Thank you for submitting Planning Application Comments

Planning Application Reference Number: 3/2023/0464

Address of Development: 107 Whalley Road, Read, BB12 7RP

SHEET:
PROPOSED ELEVATIONS 1

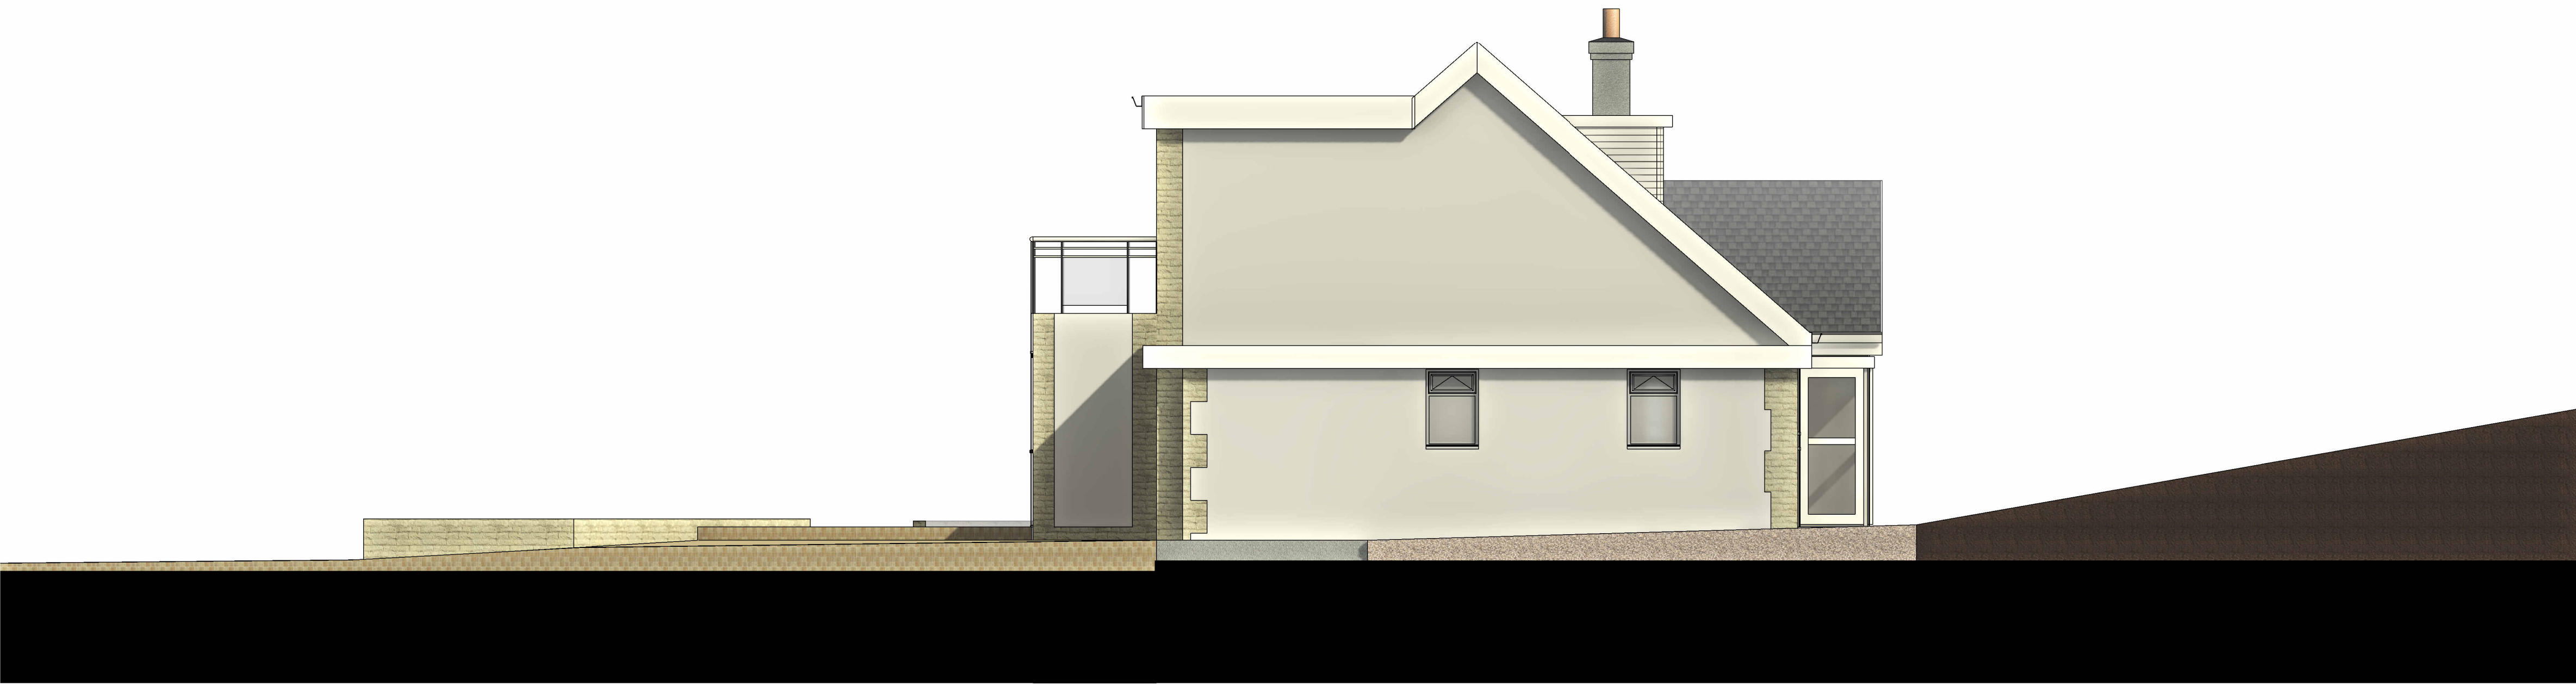
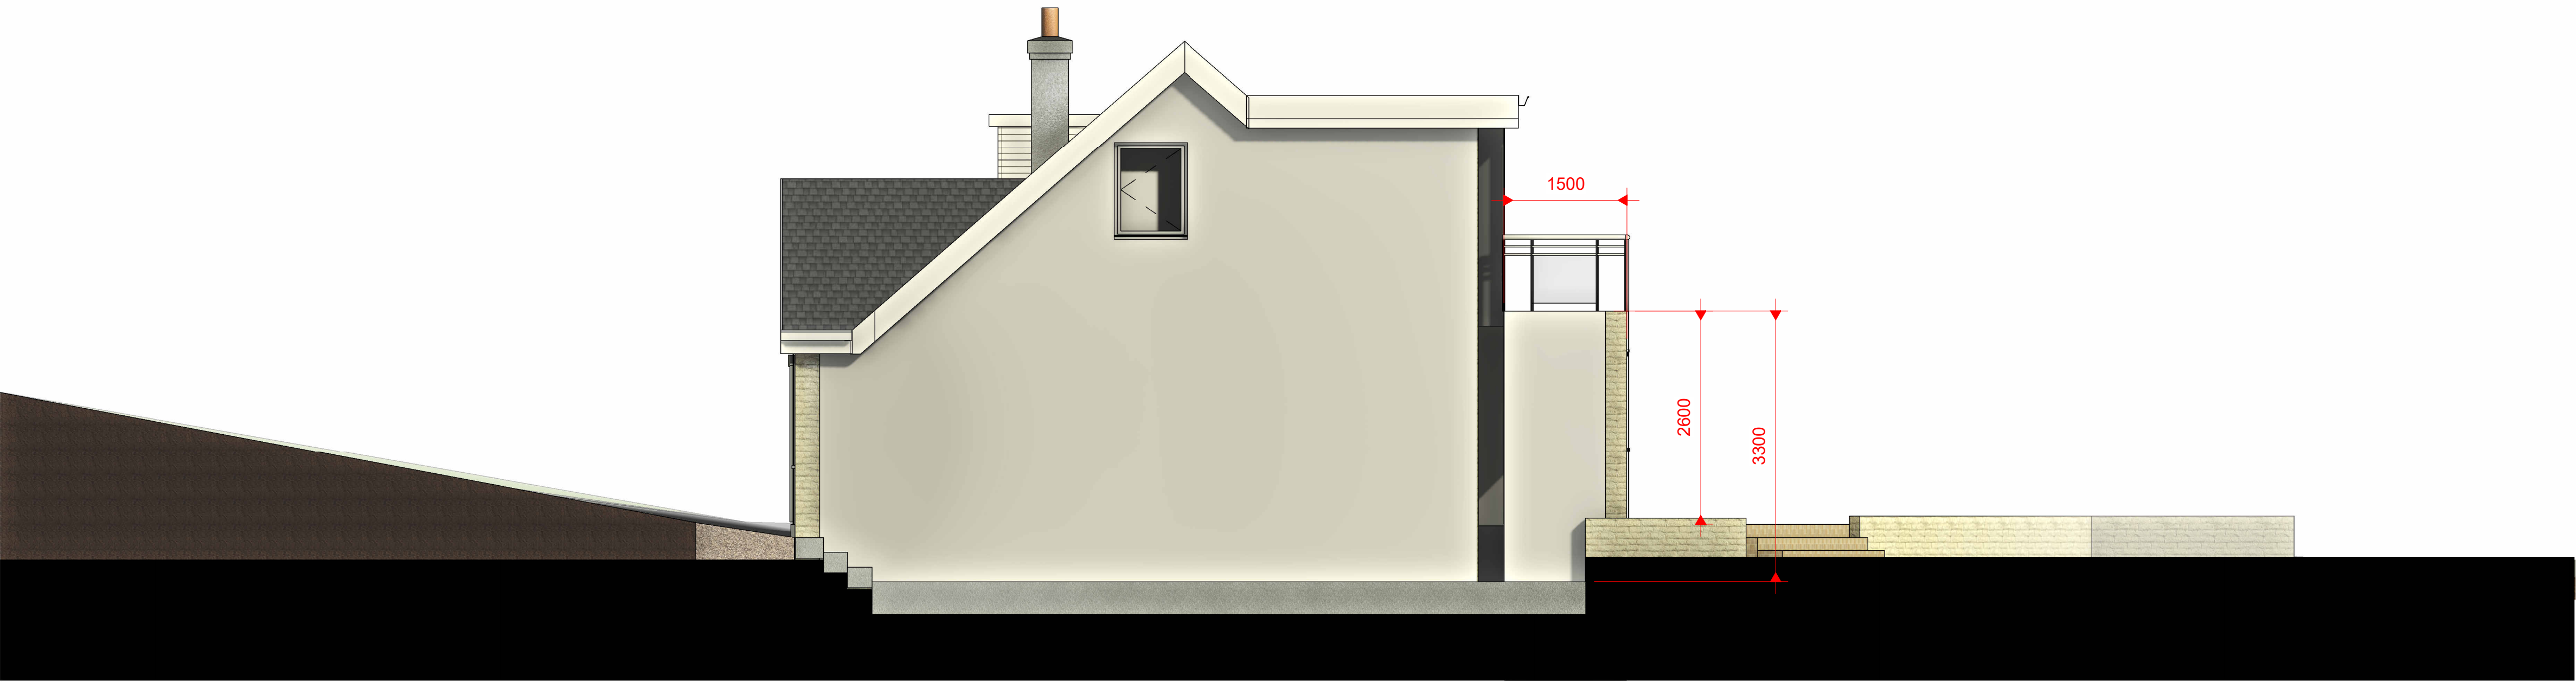
The proposed extension overshadows  and  leading to loss of light

2 1 PROPOSED FIRST FLOOR  
1 : 50

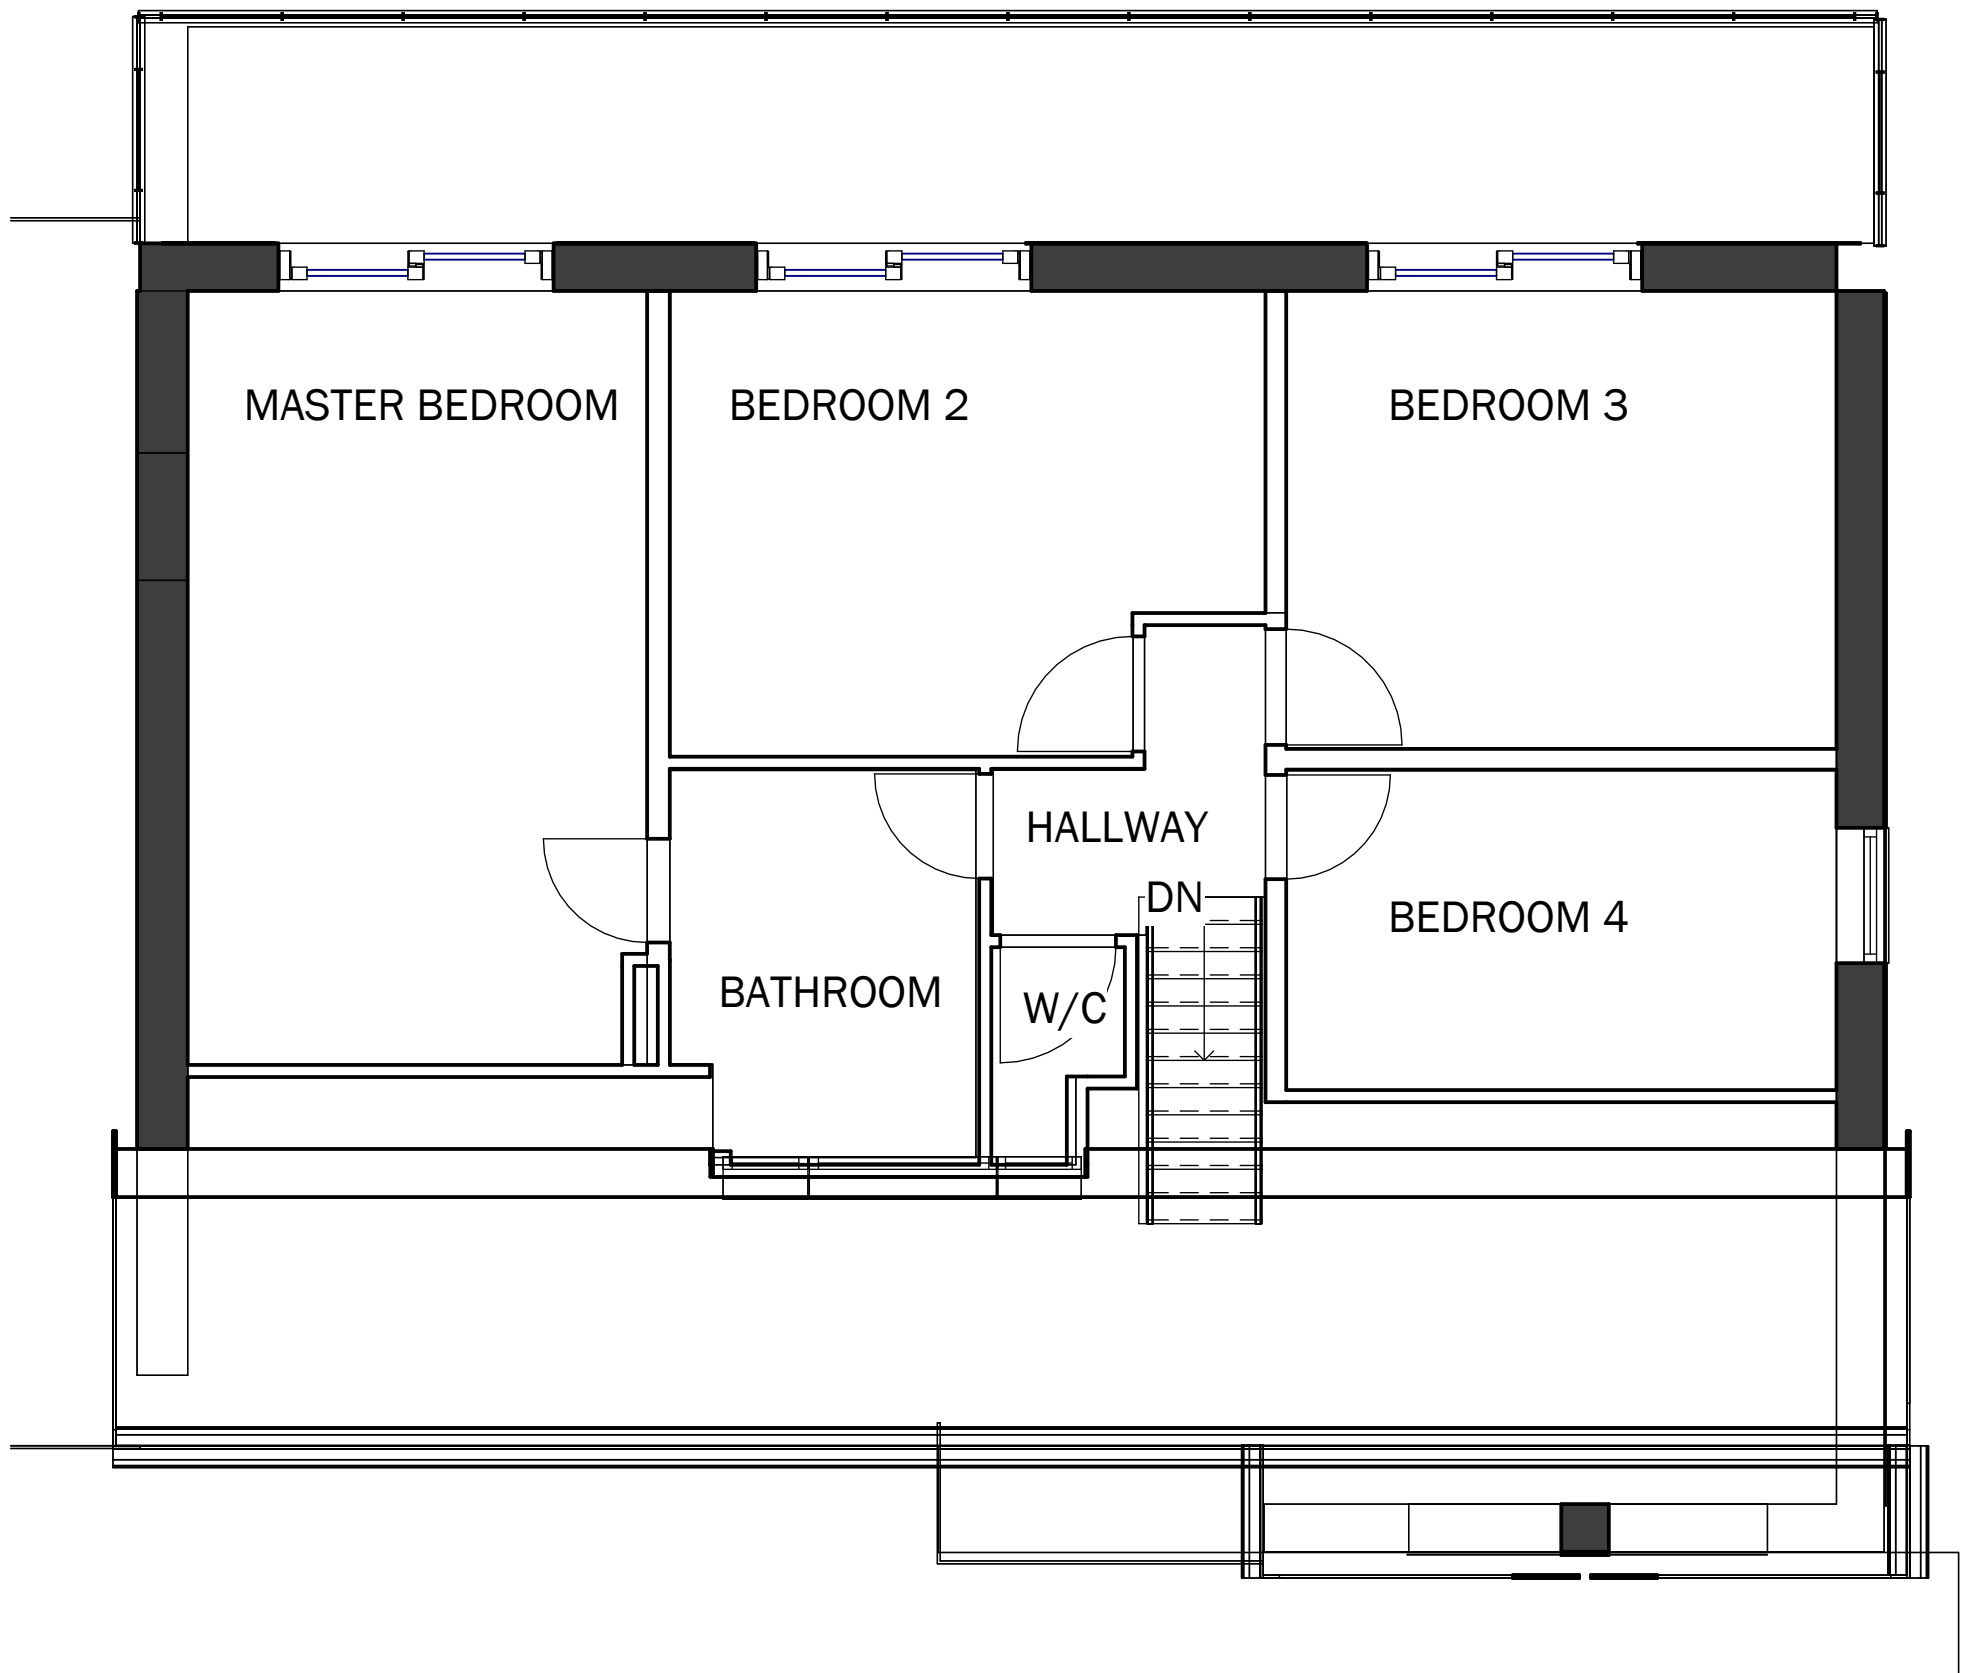
Your Comments: The proposed balcony will  leading to loss of privacy
